Urban Design

Planning Consultation Comments

RE: 19/00522/NSIP Aquind Interconnector Site, Old Mill Lane, Lovedean, Denmead

**Plate 4.12 – Graded “autumnal” colours option**

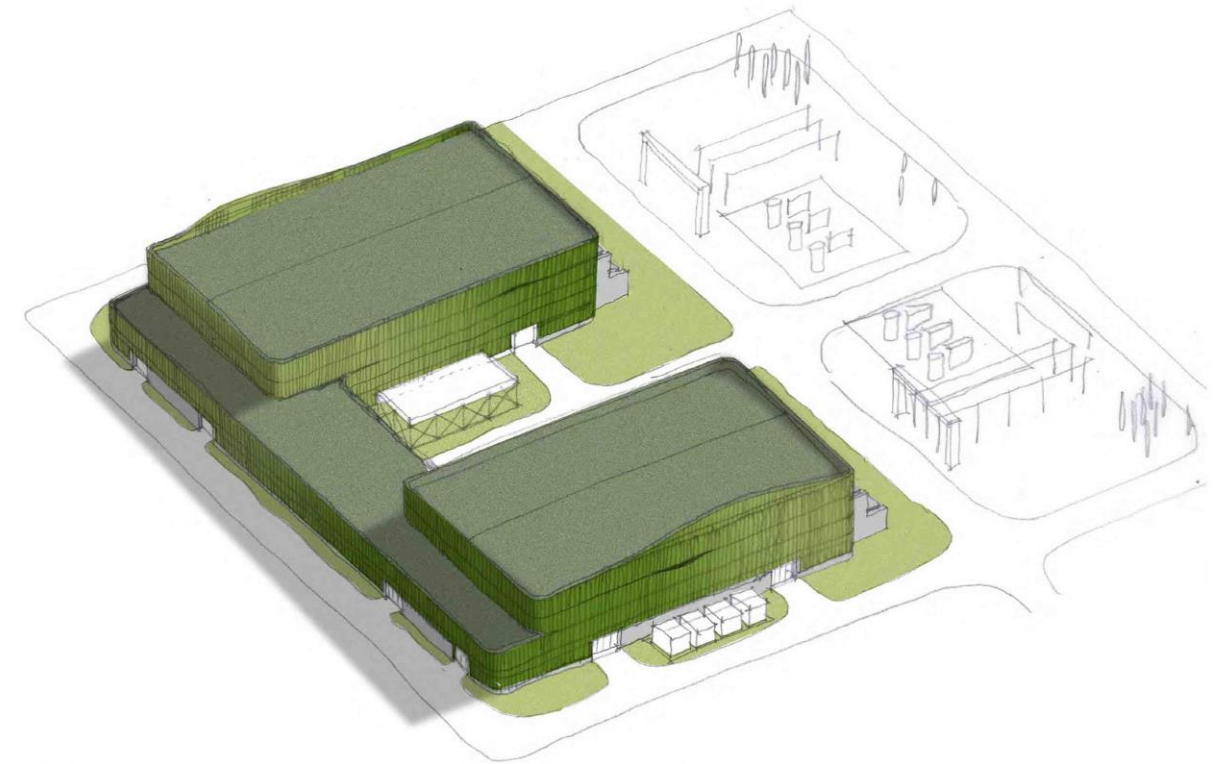
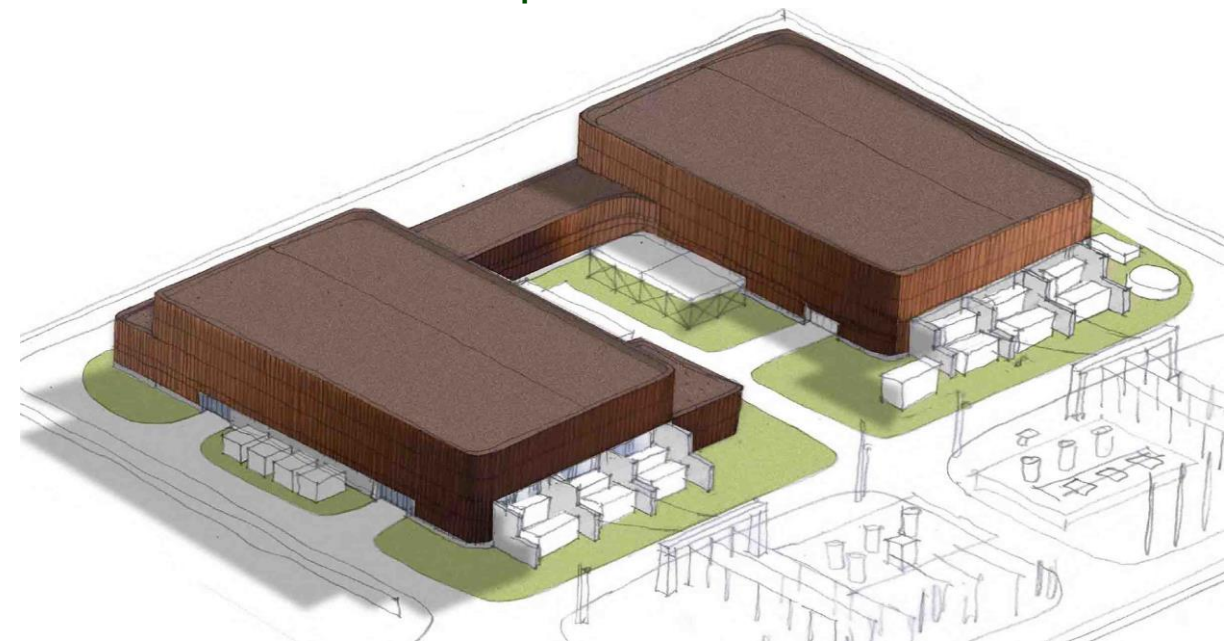
As it is presented on the DAS, it seems relatively random the choice of the colour palette within a wide spectrum of autumn colour options, which goes from light yellow to dark grey, including several tones of blue. It would be of good approach to choose the colour based on the landscape and topography analysis of the site bearing in mind which horizon each respective elevation is facing.

Furthermore, the concern raised by the Landscape Officer regarding the RAL colours suggested is shared in this comment; only dark recessive colours would be acceptable.

3. Colours will be selected from a dark recessive palette of colours within the ranges below chosen to complement the surrounding landscape.

- RAL 7043, 7010, 7009, 7039, 7003 (as per Landscape Officer suggestion)
- The roofing will be in a dark recessive non-reflective colour to minimise visual impact.

**Plate 4.13 – Curved corners sketch**

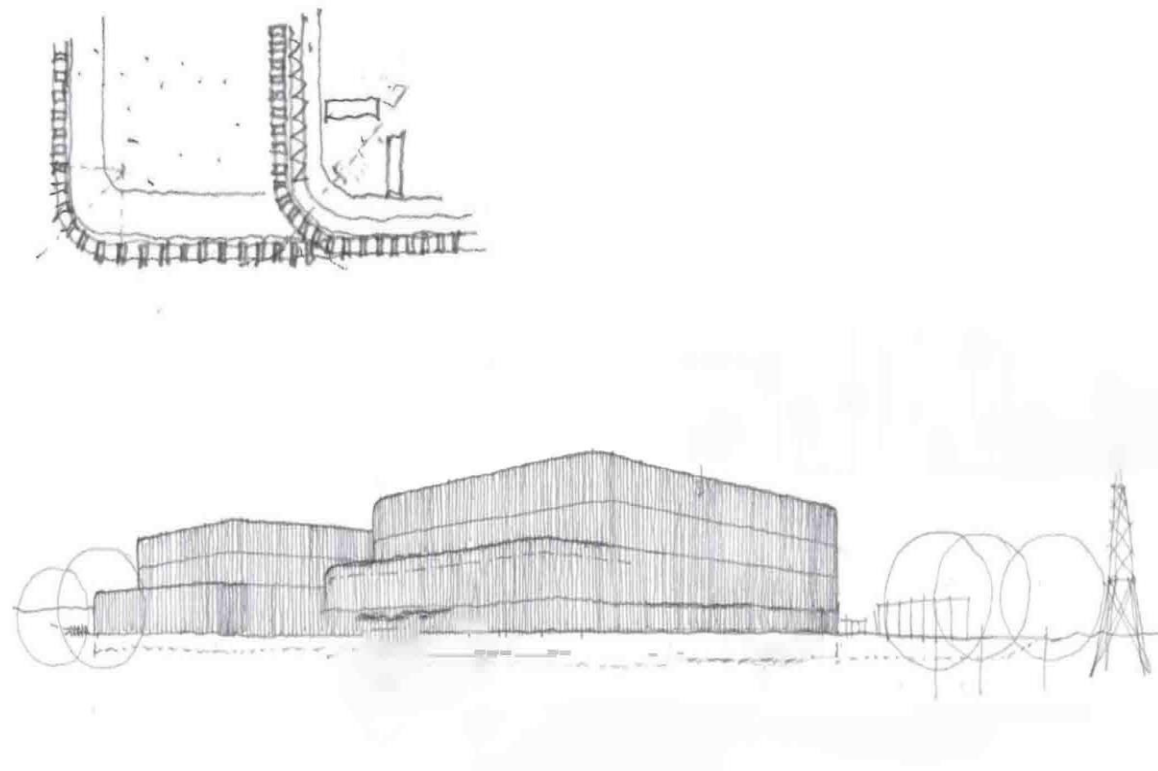
6. Curved corners will be included, to soften the visual impact and attention will be applied to relationships between the component parts of the main structures to add interest and further reduce the perceived mass of the building.

7. All materials proposed should be of high quality standards and allow for a curved corner detail.

**Plate 5.7 – Converter Station – indicative elevations**

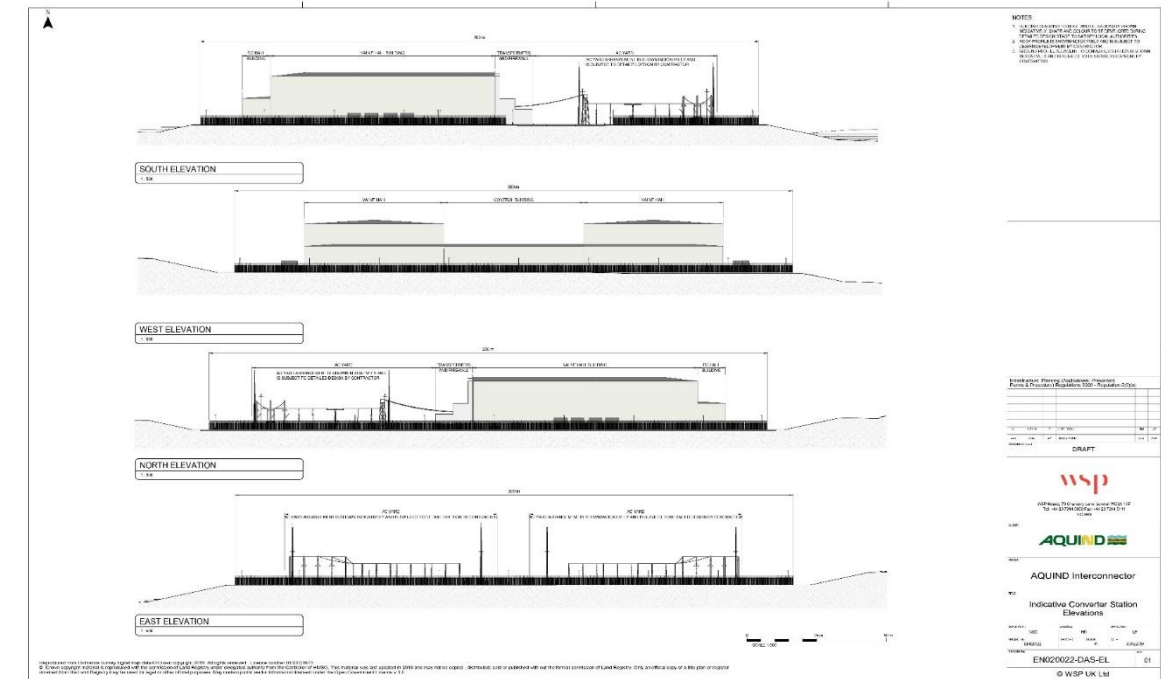
The concept idea of having vertical fins to the external treatment is acceptable in principle as it would allow for continuous curved corner details on the building and hopefully this would create an interesting texture, composed by the sequence of the proposed fins and shadow gap. Light reflections throughout the day (and the year) will play an important role to blend the building with the surroundings.

However, to ensure that the external appearance of the building is of high quality standards, a sample of the proposed pre-coated metal cladding system should be submitted. It is mentioned on paragraph 5.3.3.1 that this material incorporates insulation panels and meets the functional requirements of durability, thermal, acoustic and fire separation; however, the lack of evidence at this stage does not allow to confirm the abovementioned and it is even difficult to acknowledge how effective in this regard, this proposed illustrative material would be. It is quite

common to have large farm buildings clad in corrugated sheeting, therefore some kind of analogy would be expected to be established, ideally whilst raising the quality standards of the material.
